16 July 2021

**St John of God Richmond Hospital Redevelopment (SSD-10394)  
Request for additional information**

The Department has commenced its assessment of the application for the St John of God Richmond Hospital Redevelopment (SSD-10394). After careful consideration, the Department is requesting that you provide additional information.

Drawing Name:
Landscape Masterplan

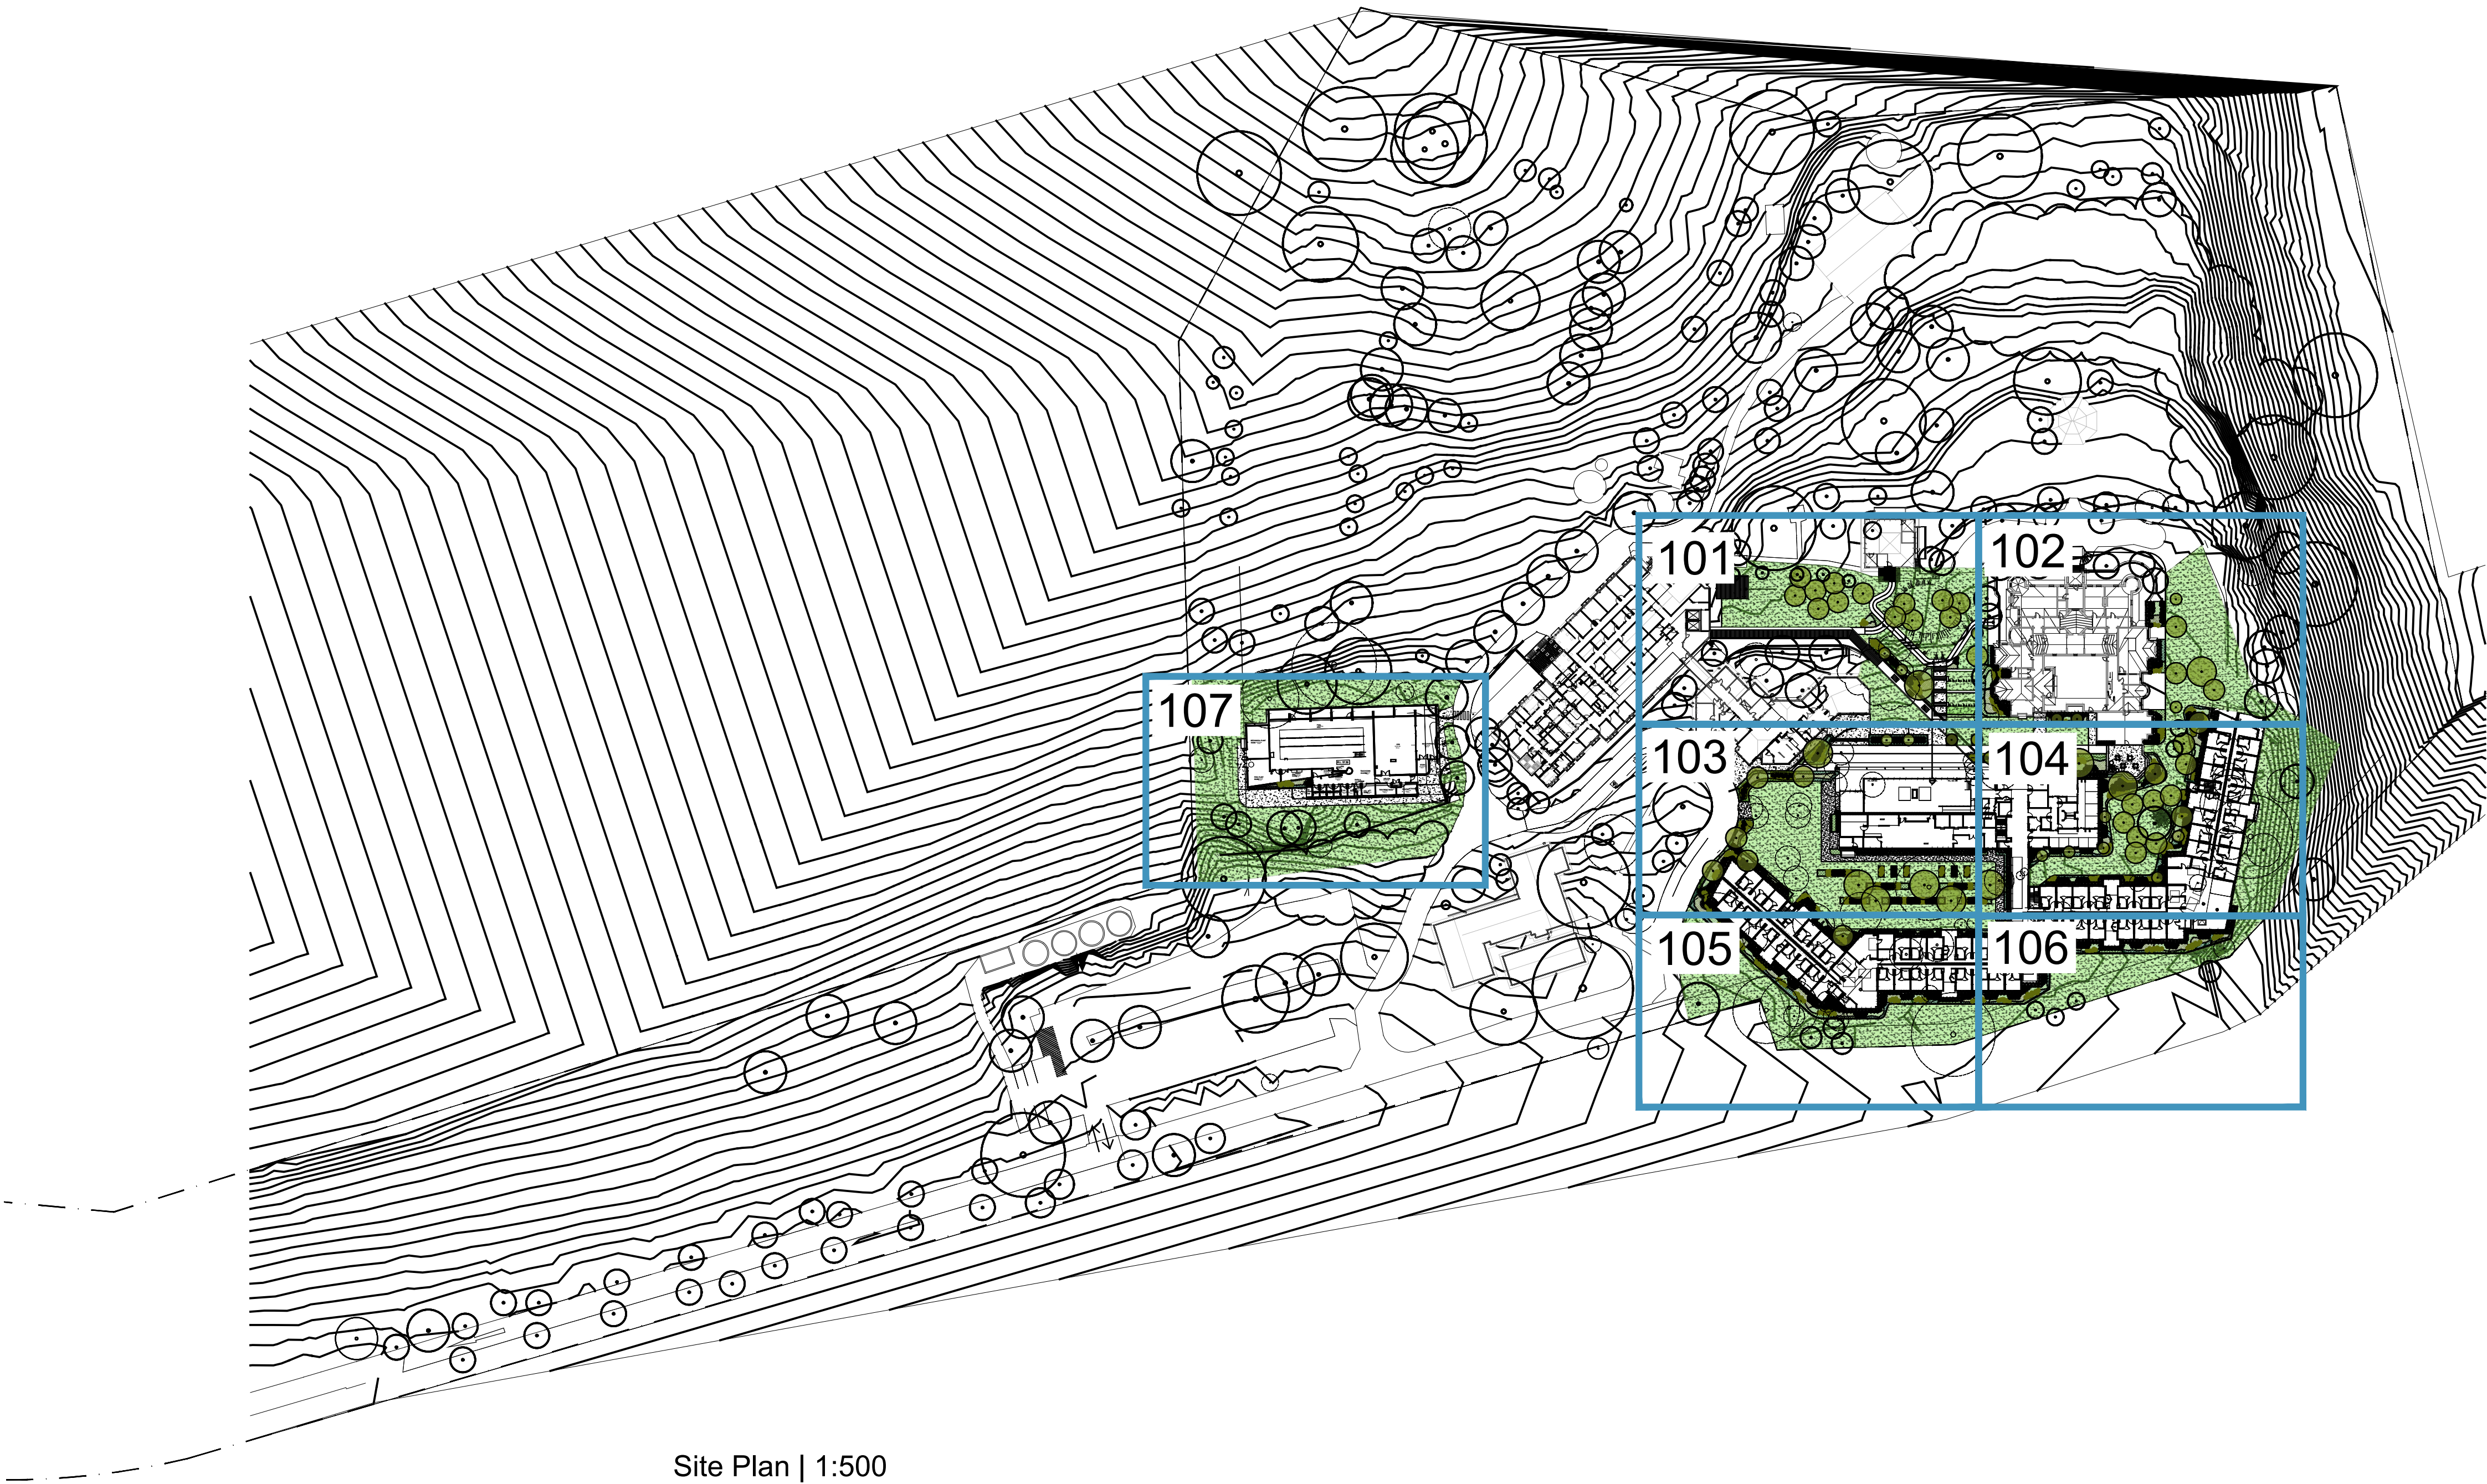
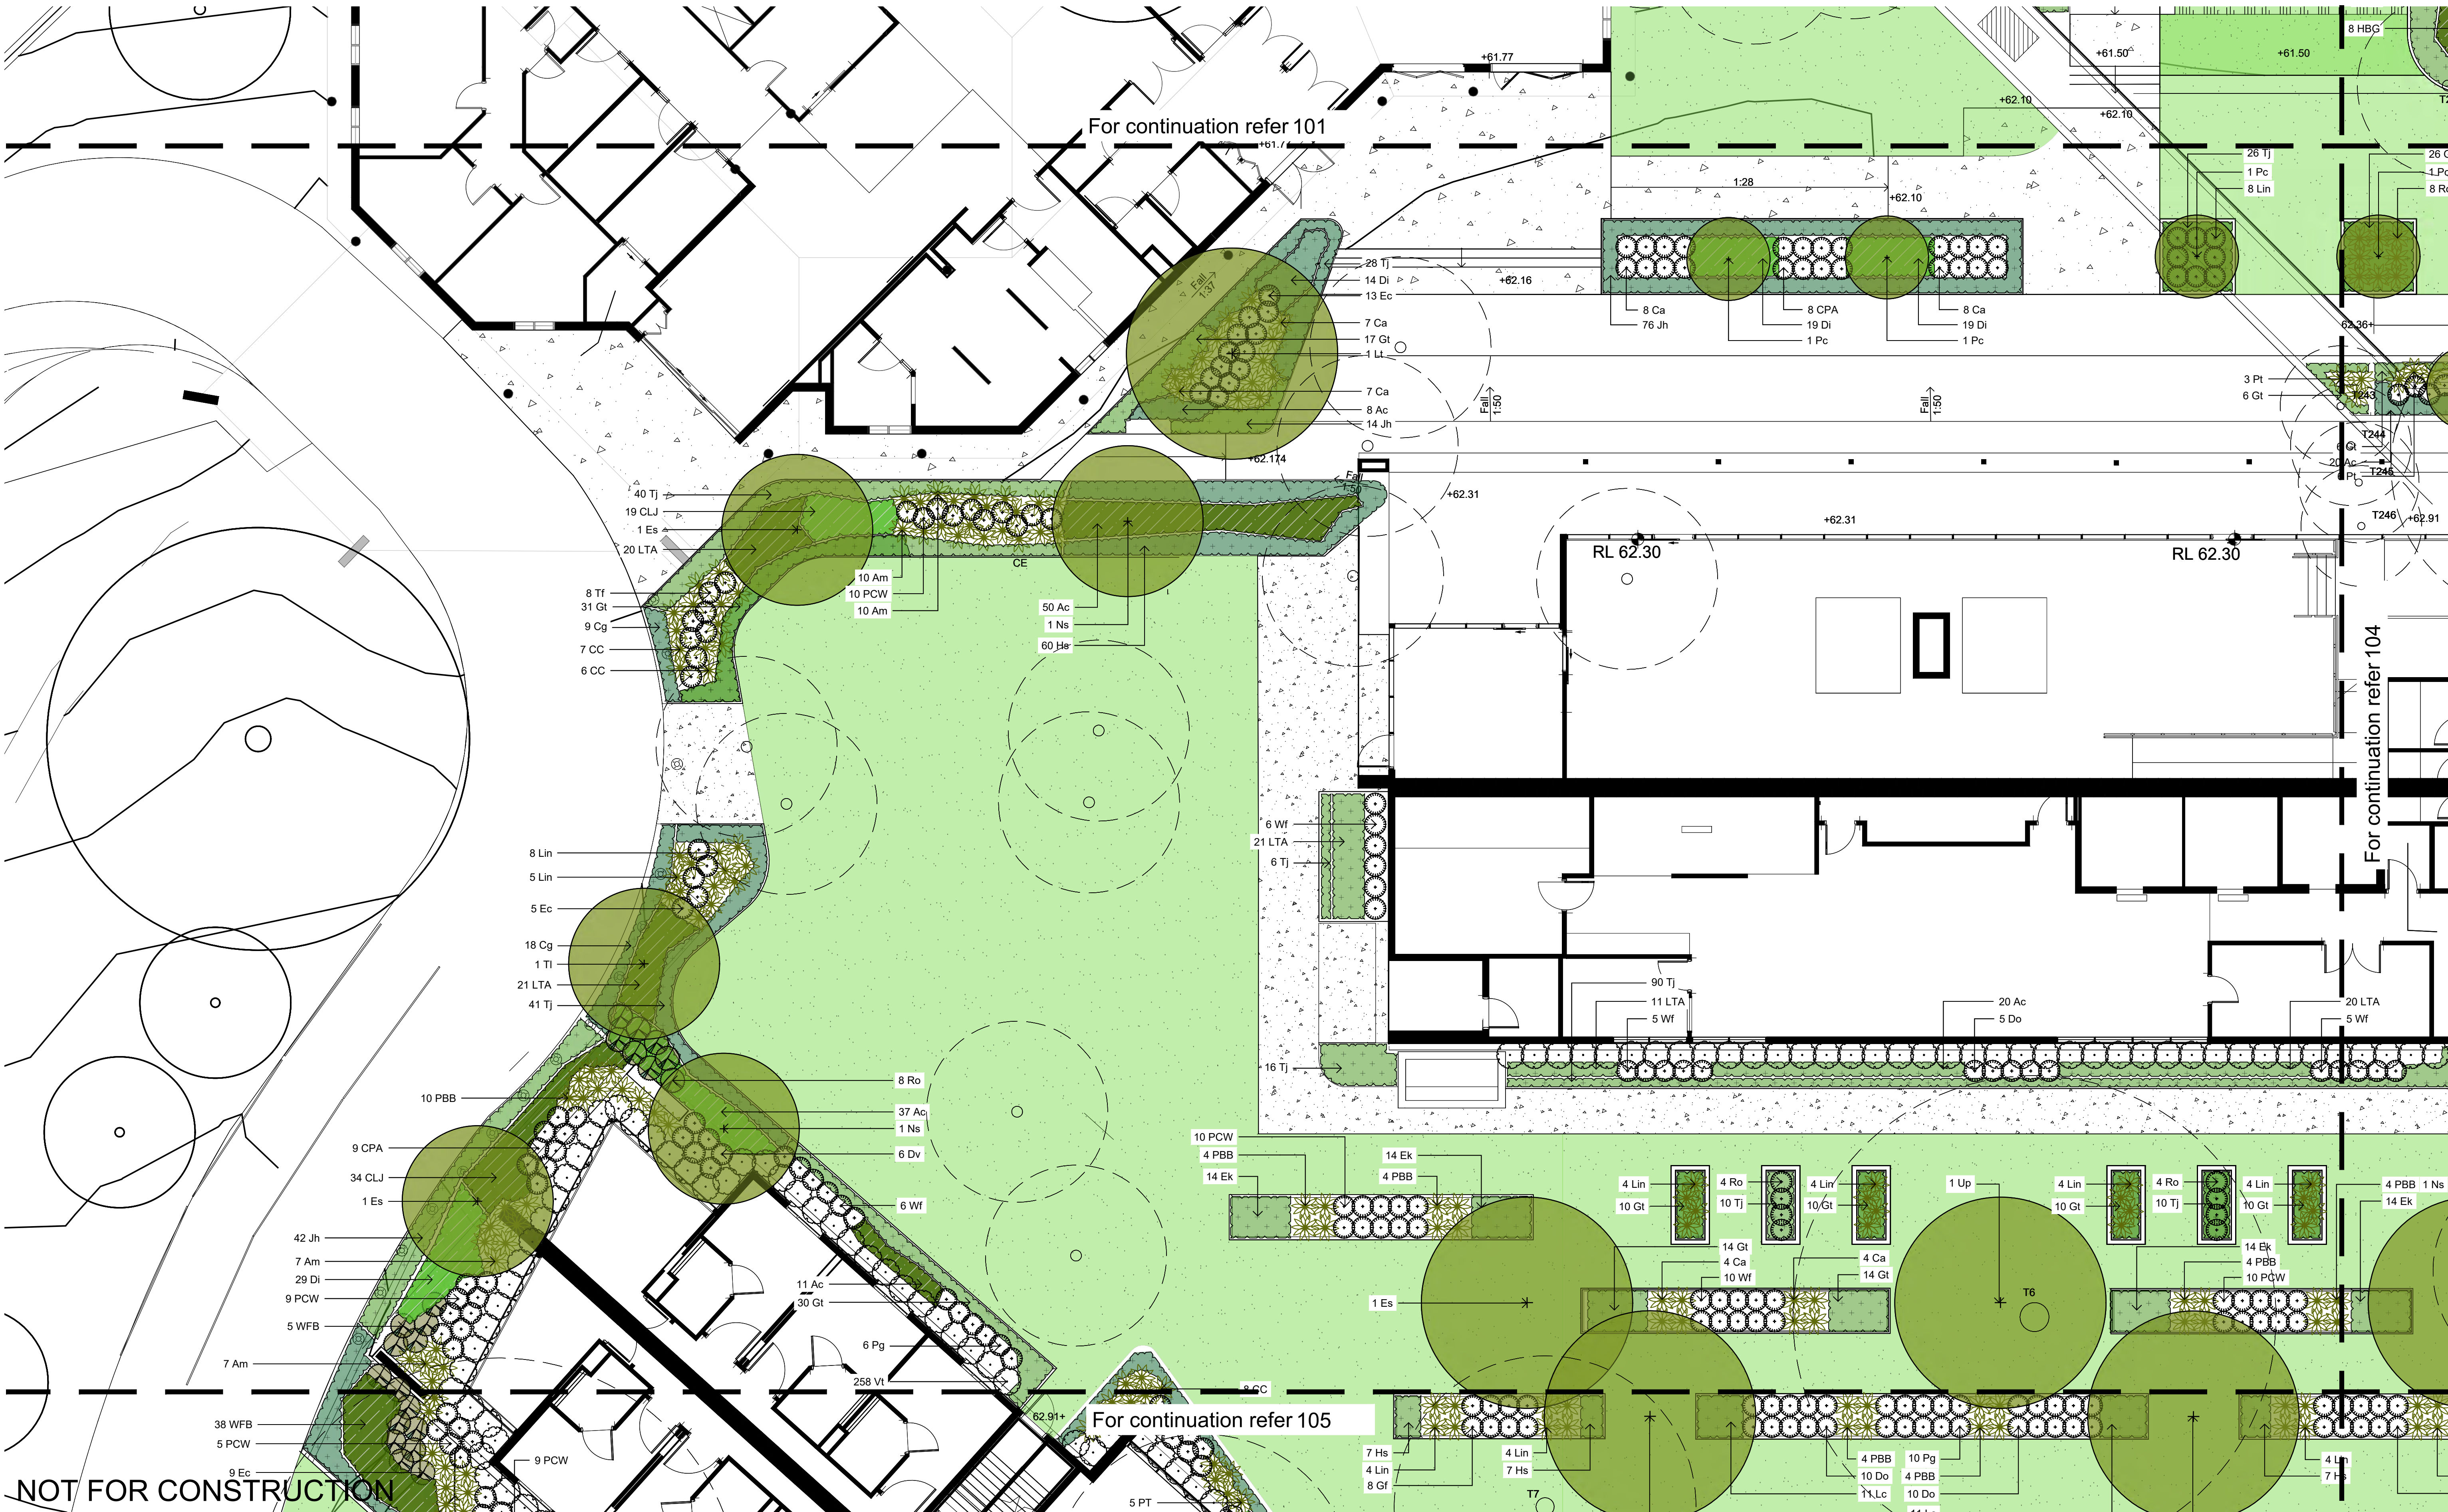
- Provide an updated tree removal plan and statement to address the additional tree removal resulting from the Wellness Centre realignment, as shown in the updated landscape plans.
- Provide an updated landscape masterplan showing the Wellness Centre realignment.
